## RPA North West Precinct Redevelopment - Response to Submissions

Project Application (MP\_10\_0166)

GROUND LEVEL PLAN

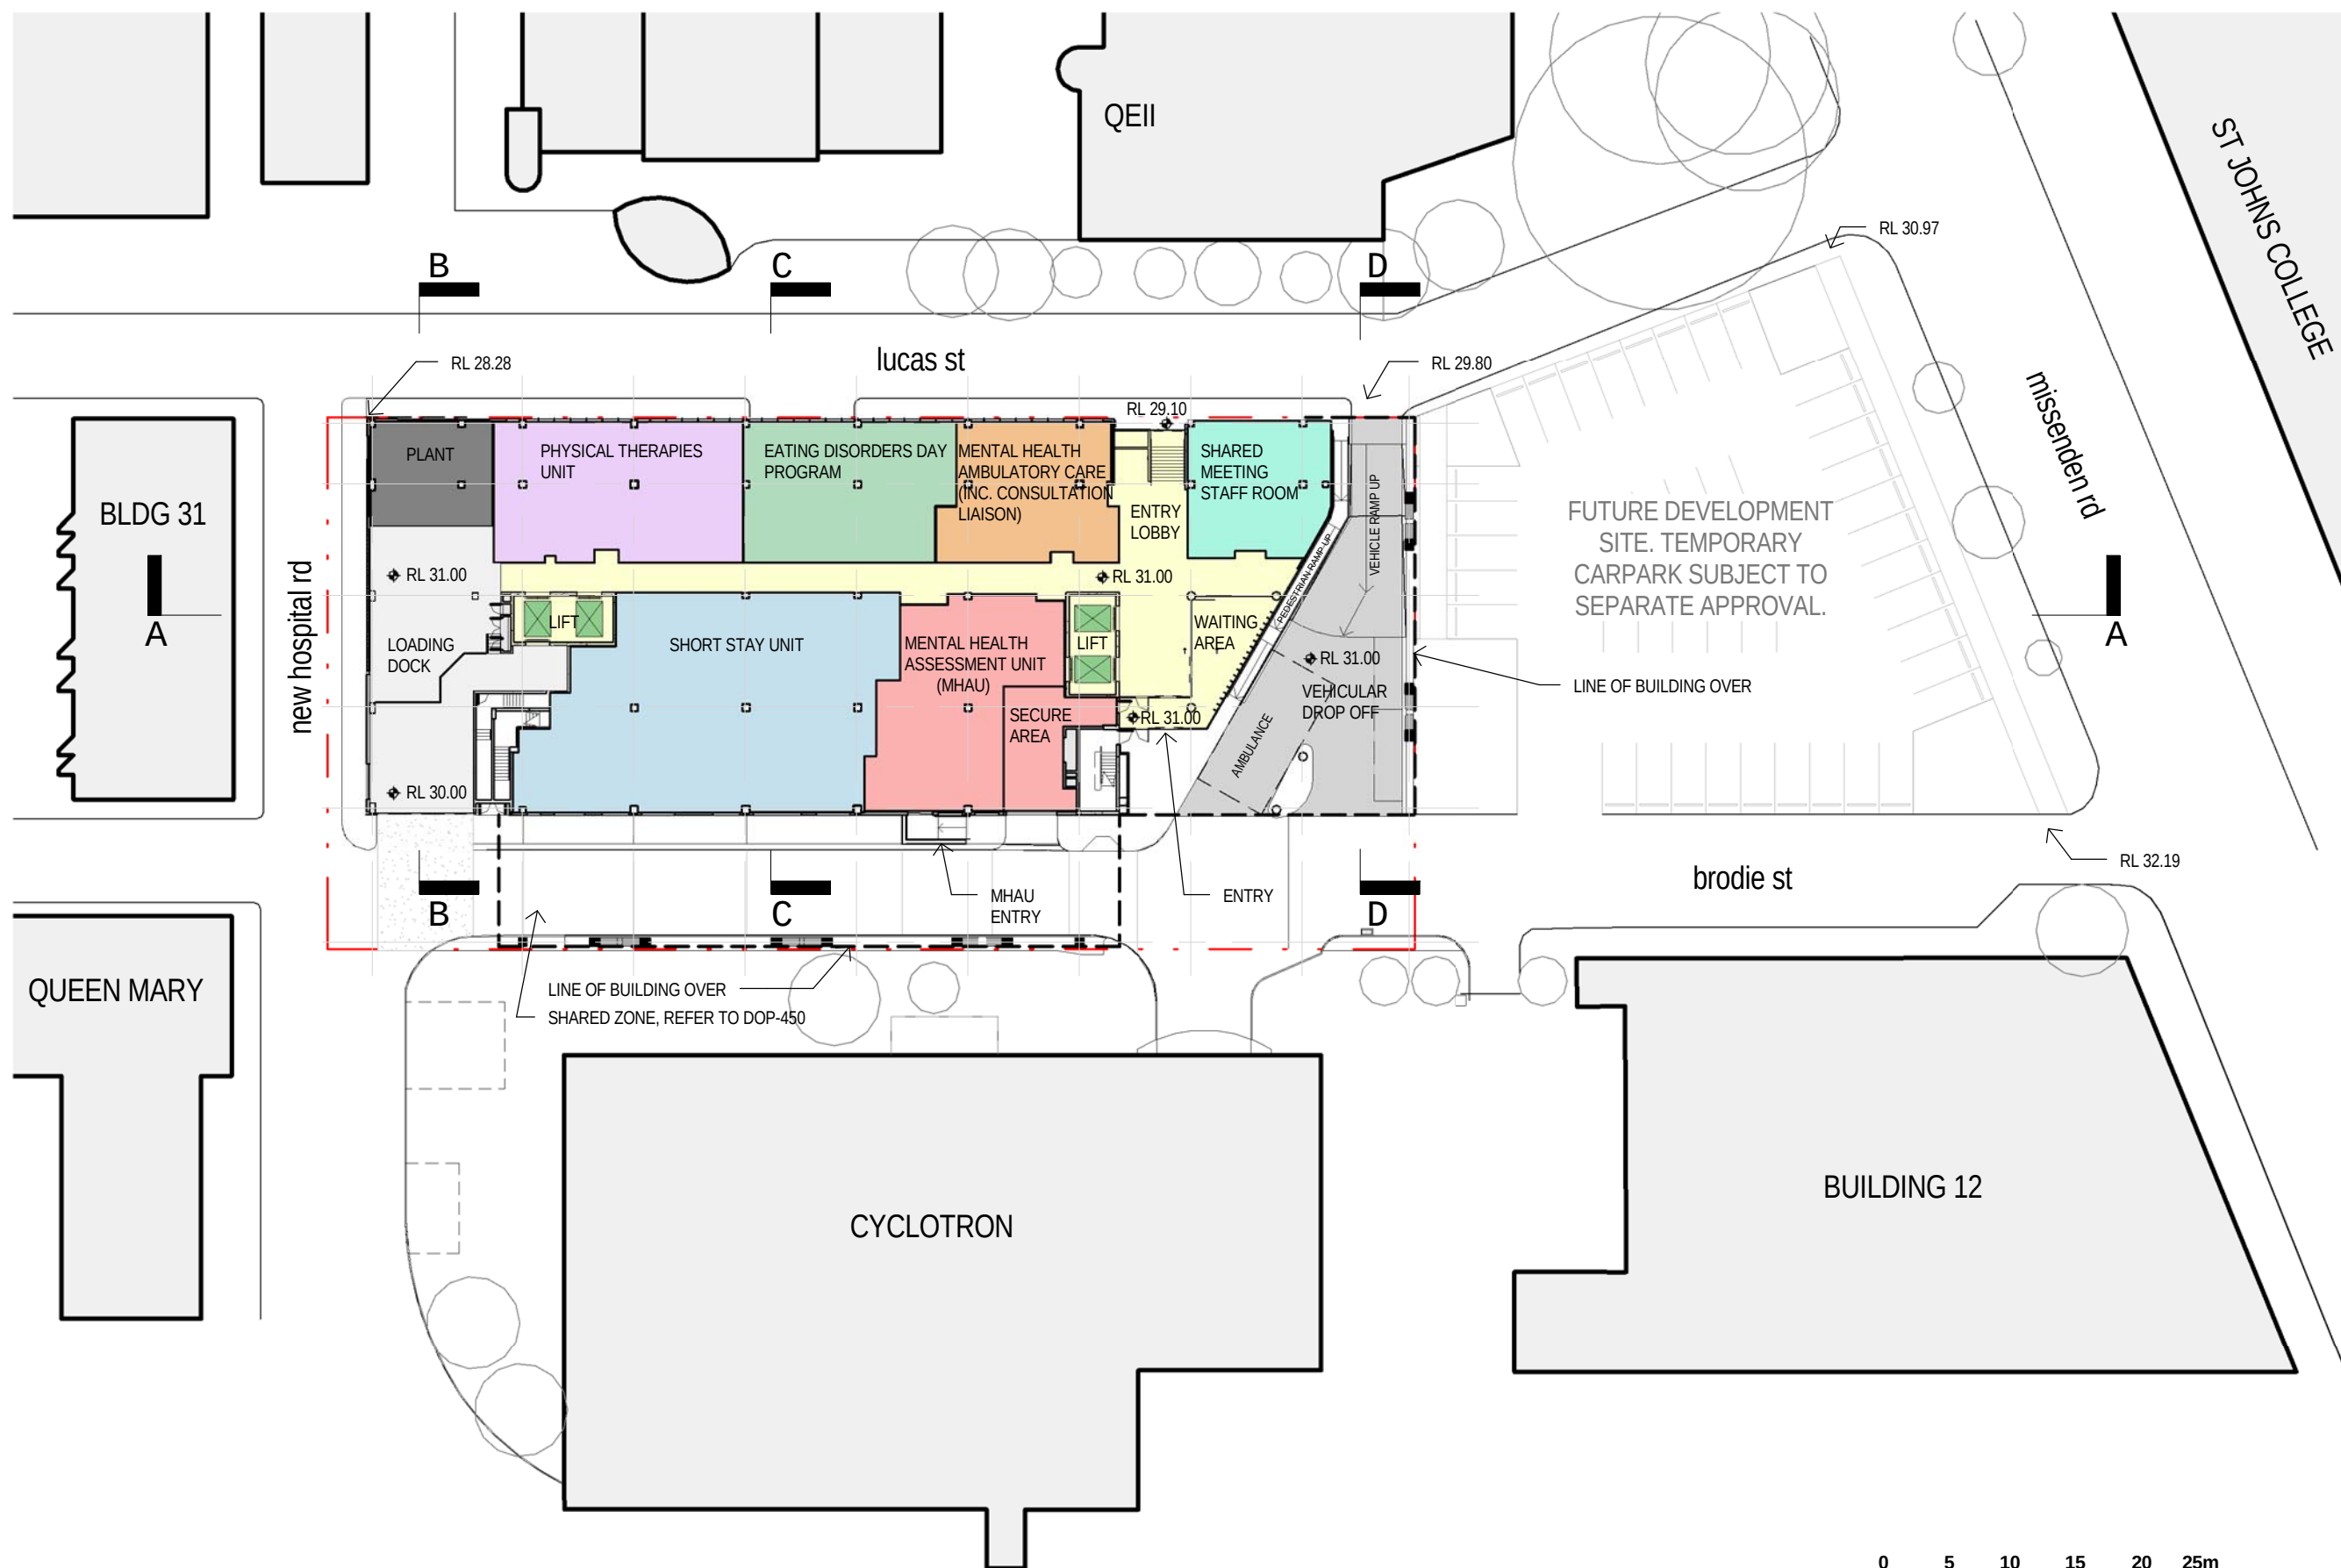
5.	The City is generally supportive of the proposal subject to the comments and issues provided below and the recommended conditions.	Noted.
6.	<p><b>Street Activation</b> A key design concern of the proposed development is street activation. The Lucas Street facade should be visually interesting and of high design quality and allow for activation of the street edge.</p> <p>The proposed primary entry is located well within the covered forecourt area at the front of the building, is not clearly identifiable from Lucas Street and may rely too heavily on signage.</p>	<p>Improvements to the design to specifically address Council's key issues include:</p> <ul style="list-style-type: none"> <li>• Repositioning of new secondary building entry off Lucas Street which provides a setback to ensure visual prominence</li> <li>• Façade detailing and relationship of solid to void</li> <li>• Providing modulation of the building towards the Missenden Road end of the site</li> <li>• Focusing the pedestrian entry more towards Brodie Street</li> <li>• Improved activation and transparency within the cantilevered section over Brodie Street</li> </ul>

Issues Raised	Proponent Response
<p>Improved design and the incorporation of a secondary entry facing Lucas Street will eliminate this issue and improve the activation of the streetscape.</p> <p>It is also recommended that the ground and first floor section of Brodie Street (underneath the cantilever) be designed with greater transparency to provide increased casual surveillance to Brodie Street.</p> <p>The development should be redesigned to consider CPTED and private activation of the public domain at street level.</p>	<p>The Lucas Street façade incorporates three components:</p> <ol style="list-style-type: none"> <li>1. Office accommodation (located to the east extent); expressed by extensive glazing to ensure street activation and openness to the accommodation contained in this zone;</li> <li>2. Lucas Street Entry that incorporates a glass curtain wall at lower levels and screening devices to courtyards contained at higher levels; and</li> <li>3. Health units/accommodation that incorporate terracotta cladding at lower levels and aluminium composite panel cladding at higher levels with a variety of opening types and infill terracotta panels.</li> </ol> <p>The Brodie Street façade incorporates terracotta cladding at ground level and timber cladding at Level 1. These cladding types have been selected to ensure a warmth at ground level.</p> <p>Consideration of CPTED principles in the design:</p> <ul style="list-style-type: none"> <li>• Public zones of the building, such as meeting rooms, staff areas, common spaces and lobbies are located to the building perimeter to ensure street activation and surveillance.</li> <li>• The building provides a “through” connection that links Lucas Street and Brodie Street and provides access to the wider Royal Prince Alfred Hospital campus.</li> <li>• The primary building entry at Brodie Street is located within best proximity to Main Hospital Public Carpark and to Missenden Road.</li> <li>• External CCTV is to be investigated.</li> <li>• Points of entry to the building are clearly defined with visible access from Brodie Street and Lucas Street to a “commons” area that links the Ambulatory Care reception, waiting area and lifts.</li> <li>• Commons areas (including seating and meeting rooms) are provided within the building entrance with direct visibility to the street and the vehicle drop off.</li> </ul>

<p>7. <b>Traffic</b></p> <p>Concern is raised regarding the traffic and loading arrangements for the proposed development and these are discussed further.</p>	<p>Comments are noted. The development site is heavily constrained and the proposed location and configuration of the loading dock is the only available and feasible option for the development.</p>

Issues Raised	Proponent Response
<p>(a) Loading The proposed loading arrangements require manoeuvres that are considered to be unsafe. Specifically, the swept paths show that: (i) vehicles entering and exiting the loading area will be required to perform u-turns and reverse through the intersection of Brodie and Hospital Road; and (ii) vehicles entering the loading area will also need to reverse through the proposed shared zone on Brodie Street. Both movements requiring manoeuvring and reversing through an intersection zone and vehicles entering the loading area also need to reverse in to a shared pedestrian zone. Both movements are considered unsuitable for a new development and it is recommended that the loading arrangements be reviewed and redesigned.</p> <p>(b) Pedestrian Safety A shared zone is proposed for the private road, Brodie Street. Loading, including garbage, patient drop off and ambulance vehicles will use this shared zone to access the site, and as discussed above, accessing the loading area will require reversing through the shared zone. Brodie Street is identified as an important pedestrian connection through the site. Concern is raised that the design will create conflict between vehicles and pedestrians resulting in safety issues and it is recommended that the area be redesigned (possibly with a separated footway of sufficient width be provided).</p>	<p>GTA have undertaken a further review of the loading arrangements (refer to <b>Attachment 4</b>). This review included an additional option being available for service vehicles to exit not only north along New Hospital Road but also south. With this new option being available, no reversing or u-turns will be required on exit.</p> <p>The shared zone has also been amended in response to Council comments to begin/end adjacent to the eastern alignment of the loading dock, resulting in service vehicles manoeuvring largely within Brodie Street, west of the shared zone and adjacent to New Hospital Road.</p> <p>A detailed review of the proposed shard zone along Brodie Street has been undertaken in light of the comments raised by Council, including provision of a separated footpath. Due to site constraints, the provision of a pedestrian footpath is not feasible as it impinges on the required road depth for Brodie Street. A revised and further detailed design of the share zone has been prepared by GTA in support of the proposal (included at <b>Attachment 4</b>) and seeks address concerns raised by Council. The design now provides a minimum 6m wide shared zone area with a posted 10km/h speed limit of a distance of approximately 70m. GTA advise that the existing traffic volumes along Brodie Street is less than 30 vehicles per hour during any peak, with traffic associated with the proposed development not anticipated to result in volumes even close to 100 vehicles per hour.</p> <p>Overall, GTA confirm that the design of the Brodie Street Share zone, together with the anticipated low traffic volumes, appropriate speed control signage and pedestrian activity ensures that the design is appropriate and in accordance with Transport for NSW requirements for a shared zone to ensure the safety of all users.</p>

DEPARTMENT OF PLANNING SUBMISSION
PAVEMENT PLAN

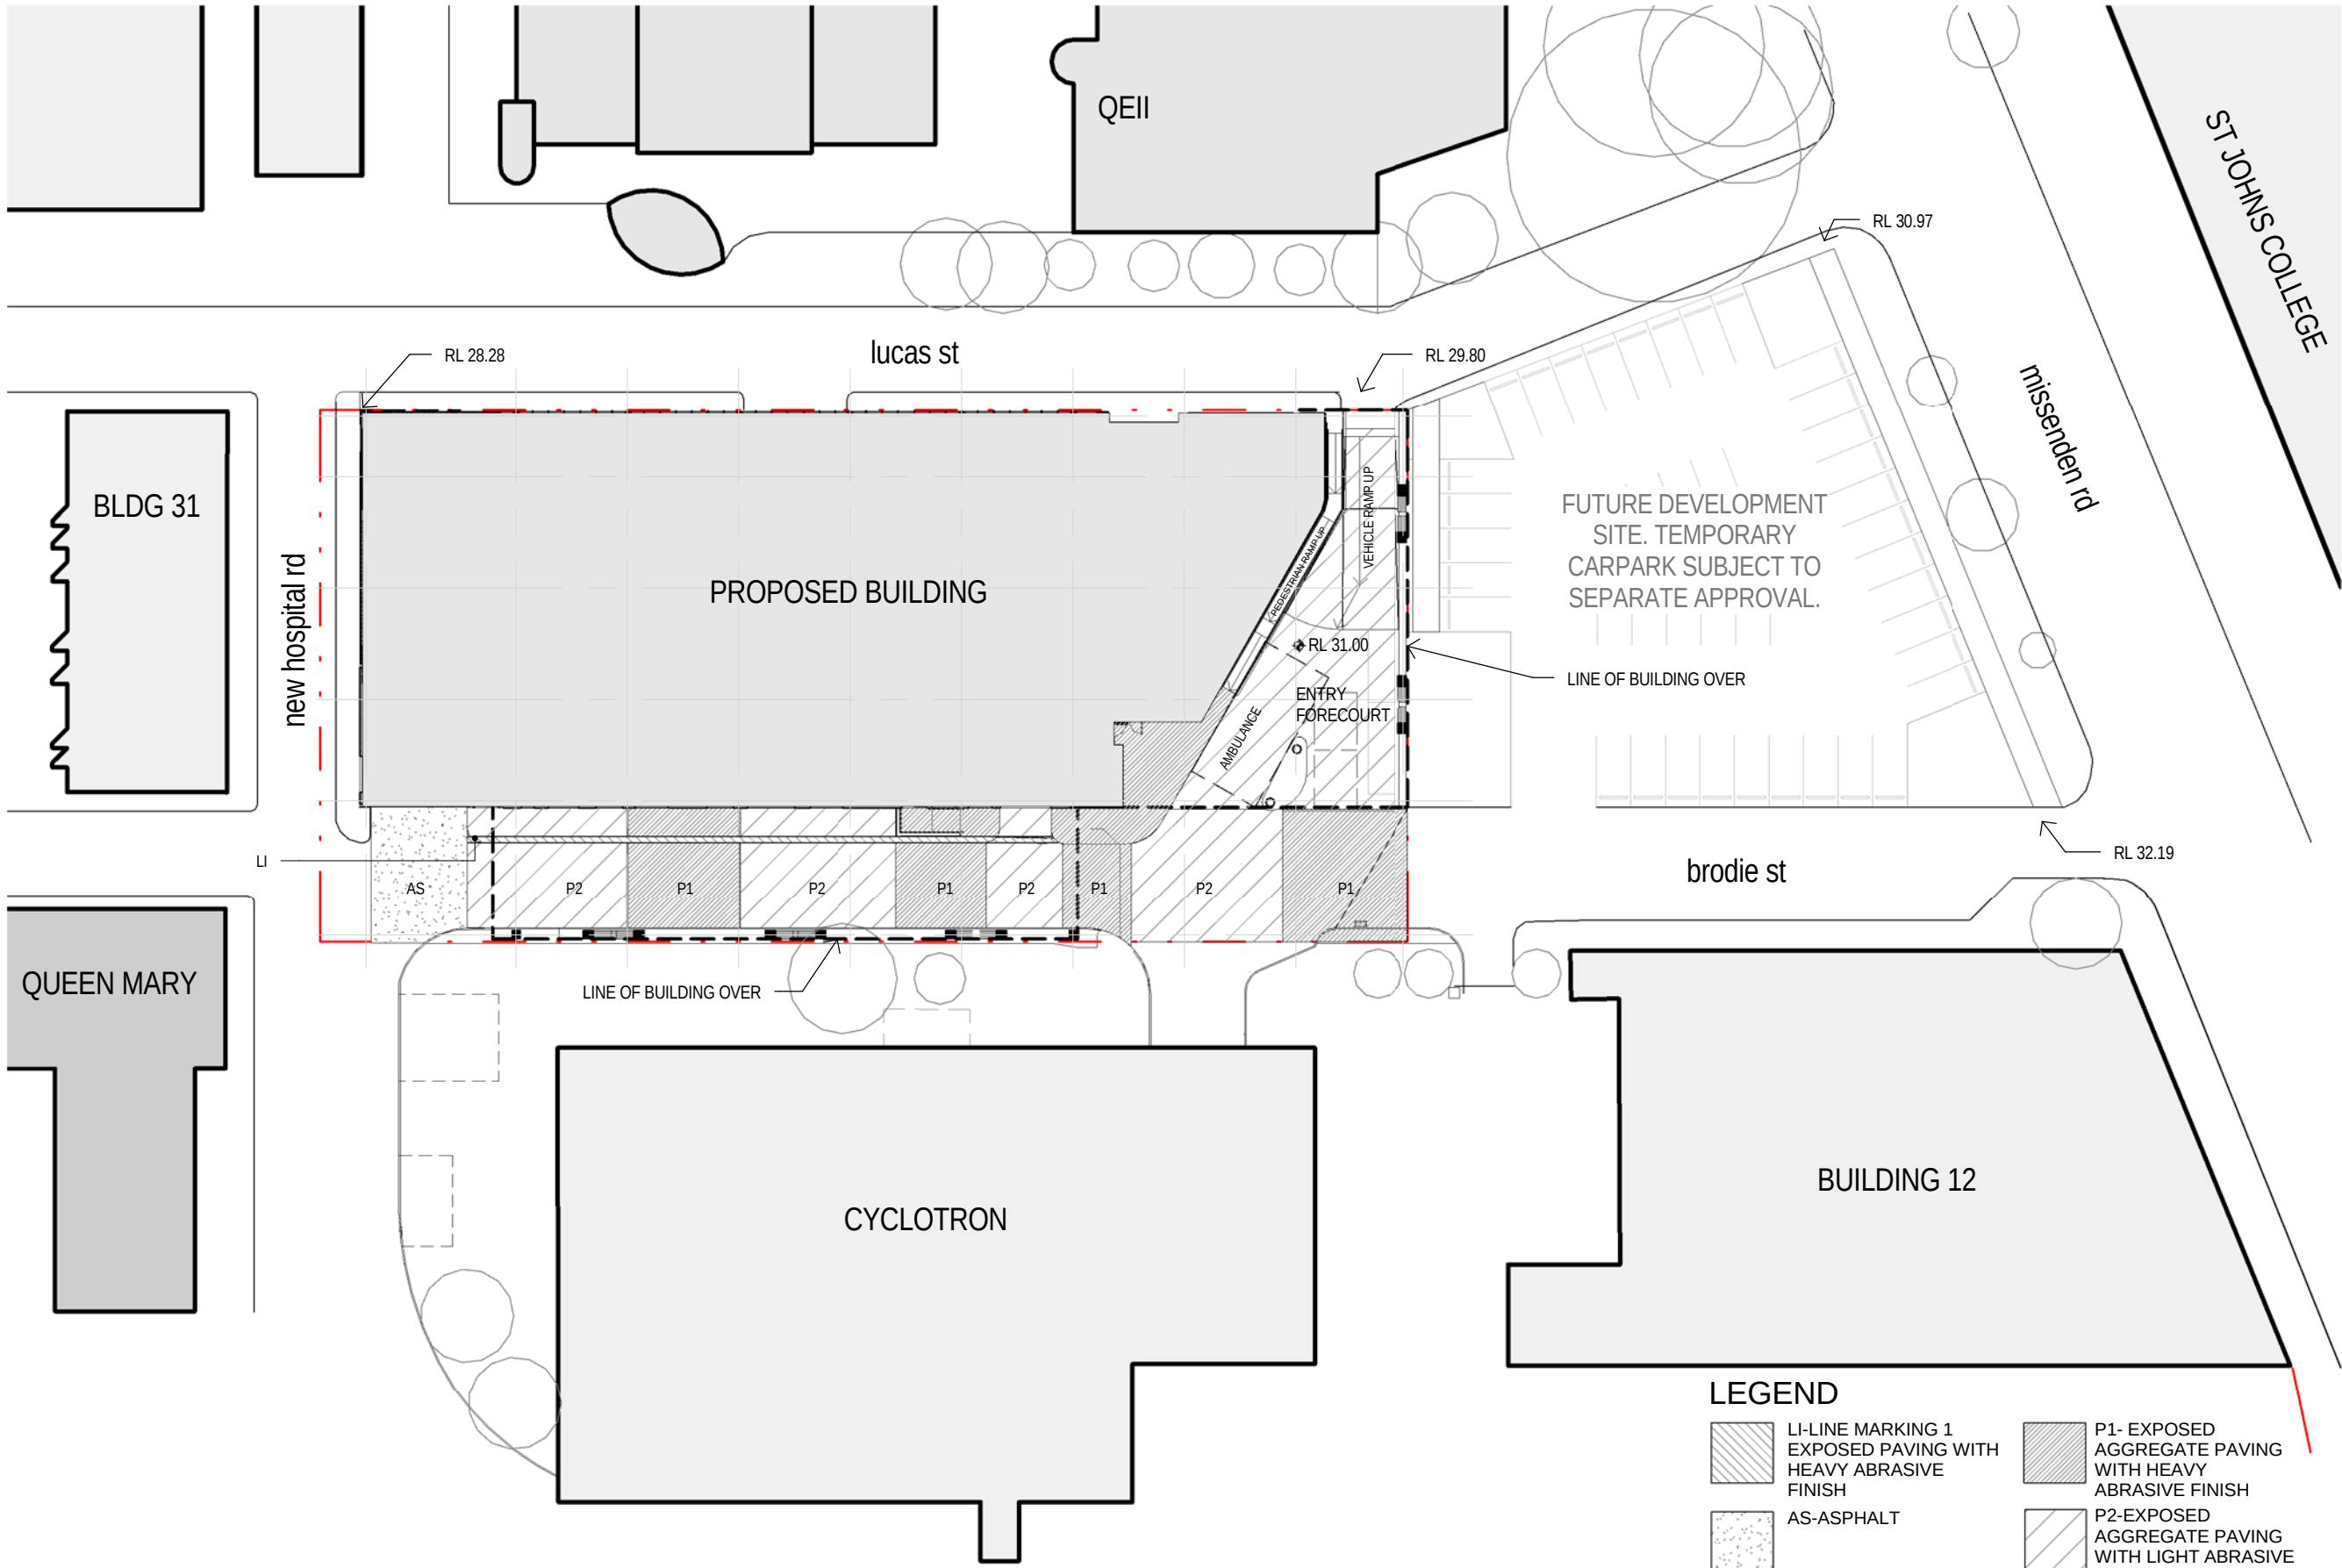
<p>8. <b>Public Domain</b> No encroachment in to the surrounding public domain will be acceptable including encroachment of soft landscaping, ramps, stairs, tactile indicators, service doors or other.</p>	<p>Noted. The proposal has been amended accordingly ensuring no encroachment into the surrounding public domain by soft landscaping, ramps, stairs, doors etc. Refer to revised architectural plans included at <b>Attachment 2</b>.</p>
<p>9. <b>Public Domain Upgrade</b> The proposal will result in an increased demand on the surrounding public domain infrastructure; therefore the development is required to upgrade the public domain along the entire frontage to the development. This includes the frontage to Lucas Street.</p>	<p>The proposed development site only has frontage to one public road, being Lucas Street. No objection is raised to the upgrade of Lucas Street, including up to its juncture with Missenden Road, in accordance with Council requirements.</p> <p>The upgrade of Missenden Road is not considered appropriate or practical. The adjoining area of land fronting Missenden Road does not form part of the Project Application. It will be the responsibility of the future redevelopment project to ensure that Missenden Road is upgraded.</p>

<p>10. <b>Landscaping of the Site – Private Roads</b> Private roadways and footways are to be visually different from the surrounding public domain to ensure private ownership is highlighted by the landscape treatment/finish.</p>	<p>Noted and support approach. A feature paver is provided to the vehicle drop-off and Brodie Street to highlight private ownership and use as a share zone. Further, the boom gates at the perimeter of the Hospital grounds help delineate these are private roads.</p> <p>It is also noted that roads are able to be constructed as 'Development permitted without consent' under the Infrastructure SEPP within the Hospital grounds.</p>
<p>11. <b>ESD</b> The application proposes a target of minimum 4-star Green Star rating. Recommended conditions of consent has been included in Attachment A requiring the achievement of the 4-star Green Star rating.</p>	<p>Strongly object to condition mandating a 4 Star rating be achieved. Such a requirement is considered to be unreasonable and onerous. It is recommended that the general approach agreed between Health Infrastructure and the Department of Planning and Infrastructure to "target" Green Star rating is adopted.</p>
